From: Laura Gibbons [REDACTED]
Sent: 04 January 2022 13:46
To: Planning.Responses [REDACTED]
Cc: David Easton [REDACTED]
Subject: RE: Planning Consultation on: A/256/21/RES

Engineers Comments Regarding Surface Water Drainage

Application No: A/256/21/RES
Registered: 23rd December 2021
Site Address: Land North of Water Lane Angmering
Grid Reference: 507574 105146
Description of Works: Approval of reserved matters following outline consent A/40/18/OUT for the erection of 525 No residential dwellings with associated parking, landscape, play areas & public open space.

Tree protection plan
Location of trees, categorisation & protection/management proposals

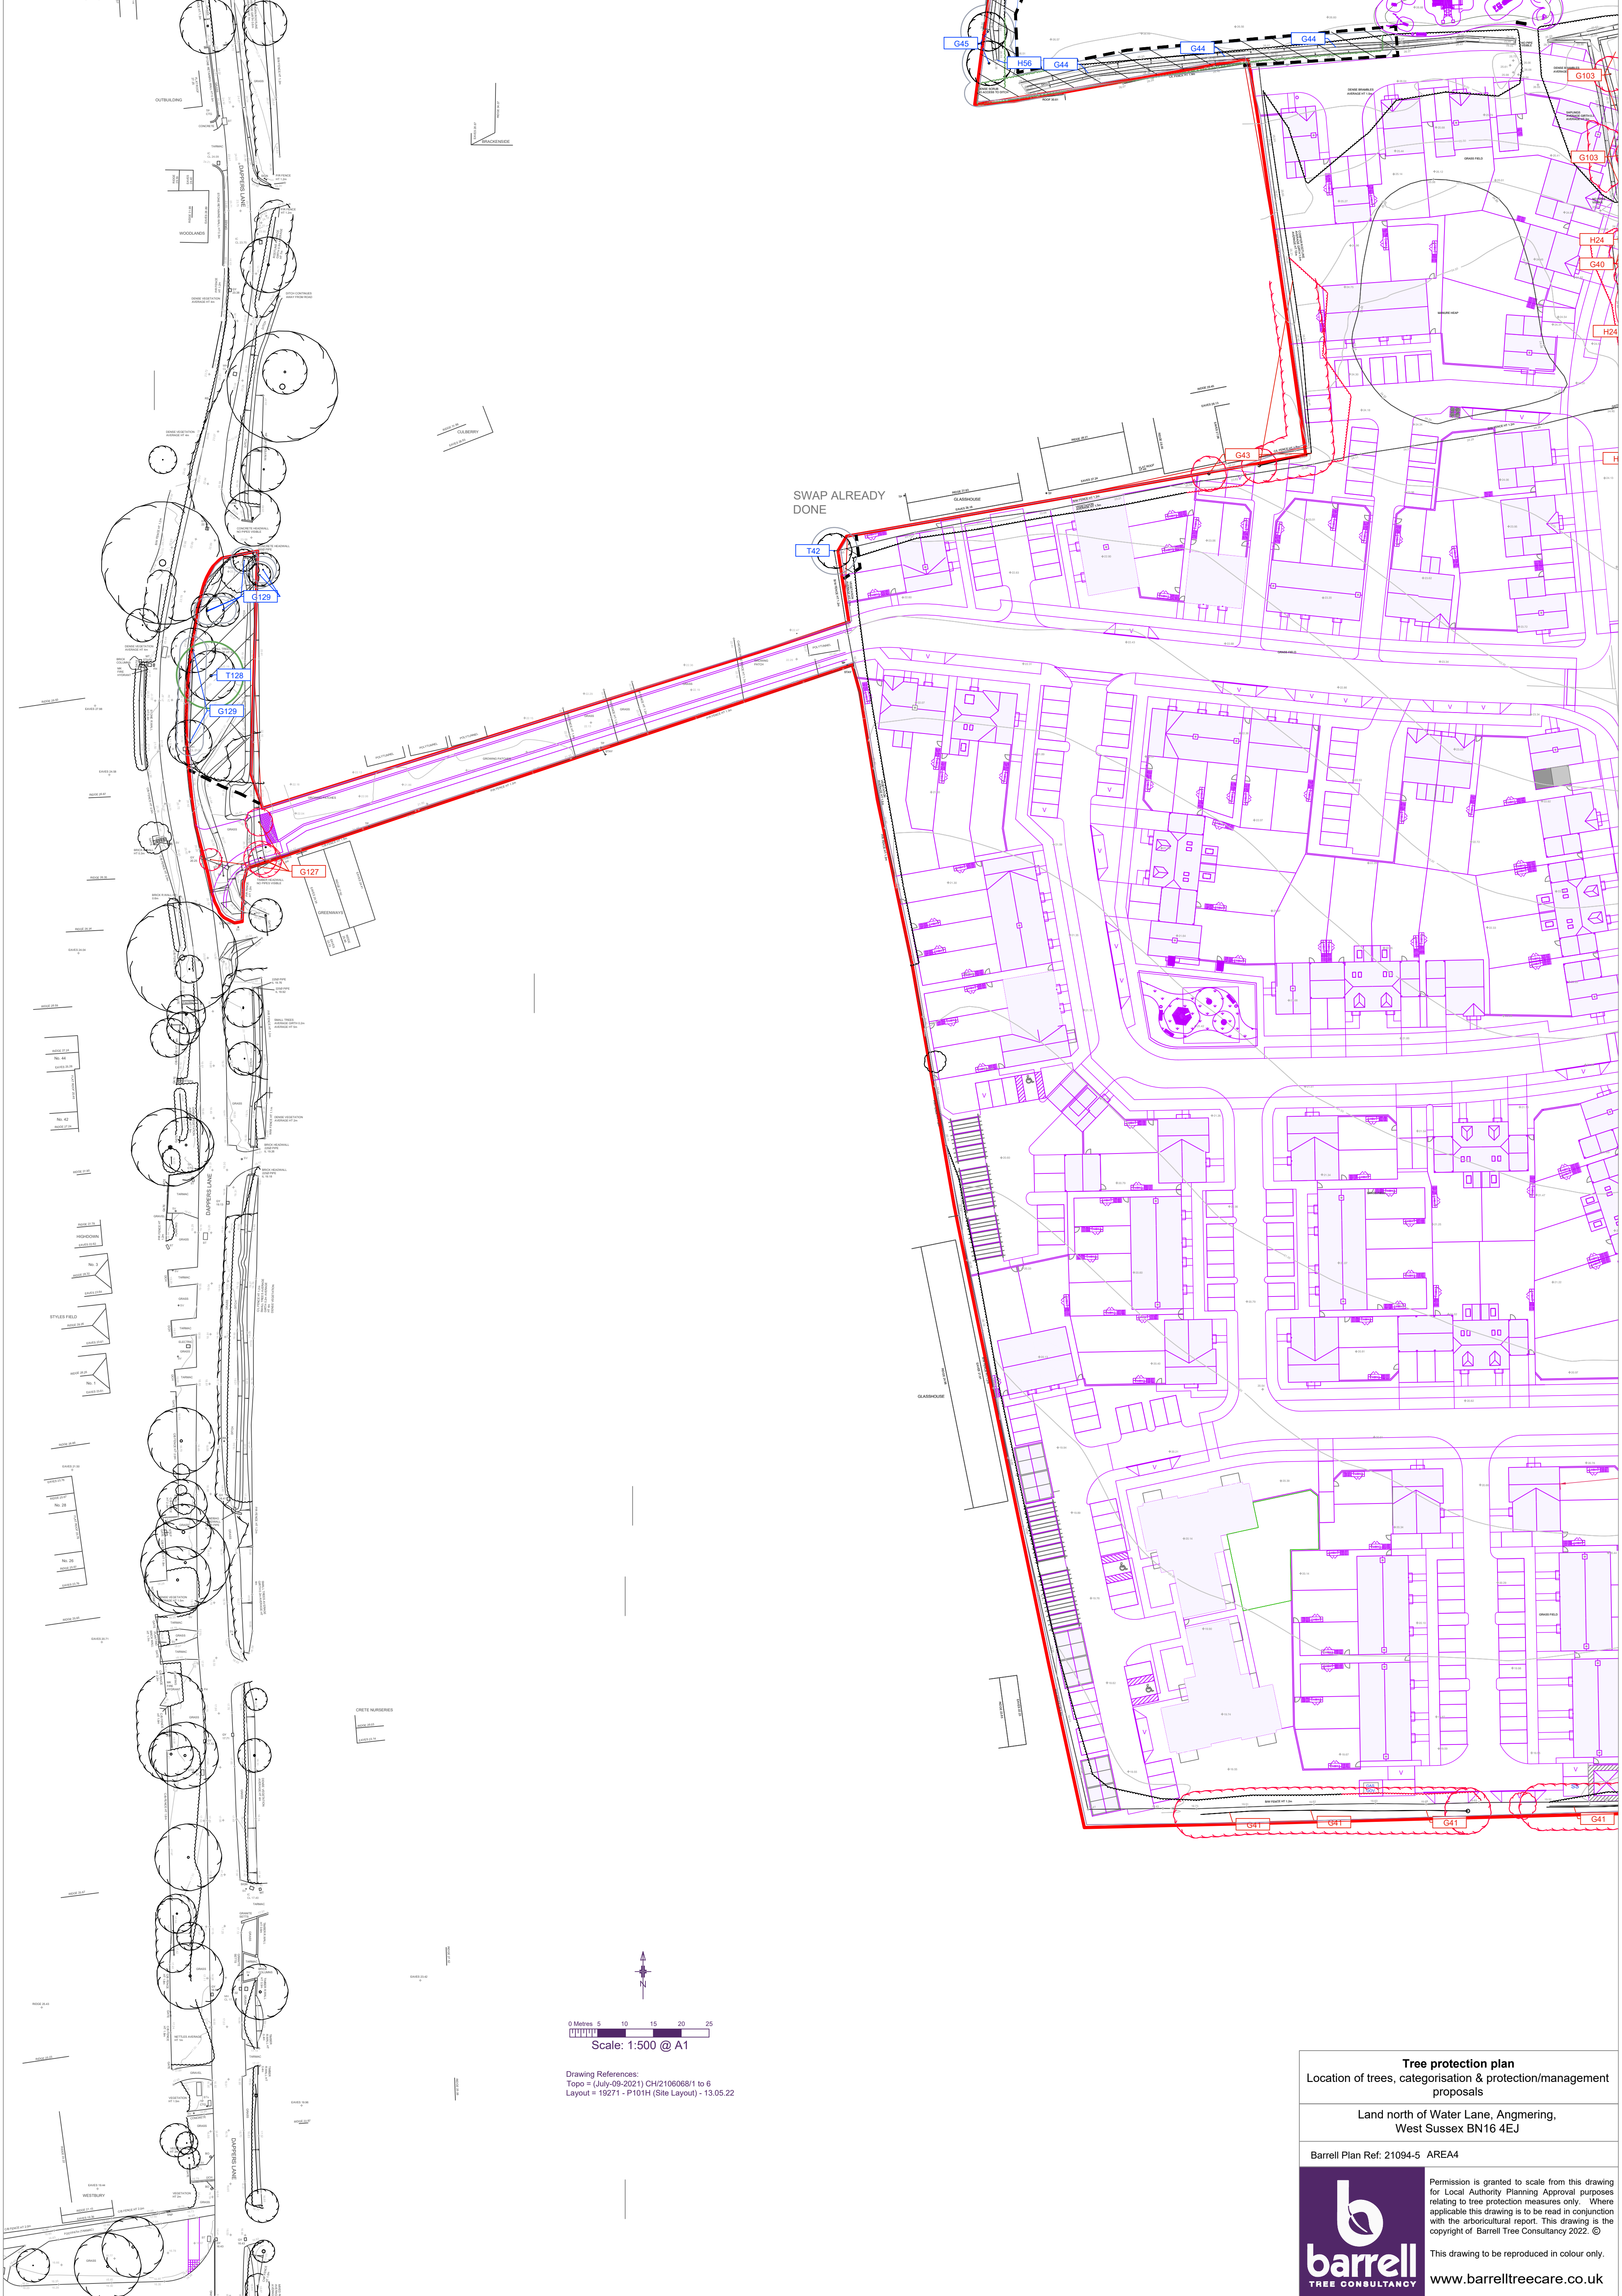
3. Confirmation of whether urban creep has been applied to calculations is required. Please confirm and evidence this.
4. Two perpendicular cross sections per basin should be provided.
5. Flotation calculations should be supplied to evidence that it will be possible to deliver the basins as proposed and that their design will adequately consider the risk of floatation.
6. We note that a number of trees are proposed in close proximity to drainage features. Root potential areas must not conflict with surface water drainage features. Please supply tree root potential plans which also consider drainage features.
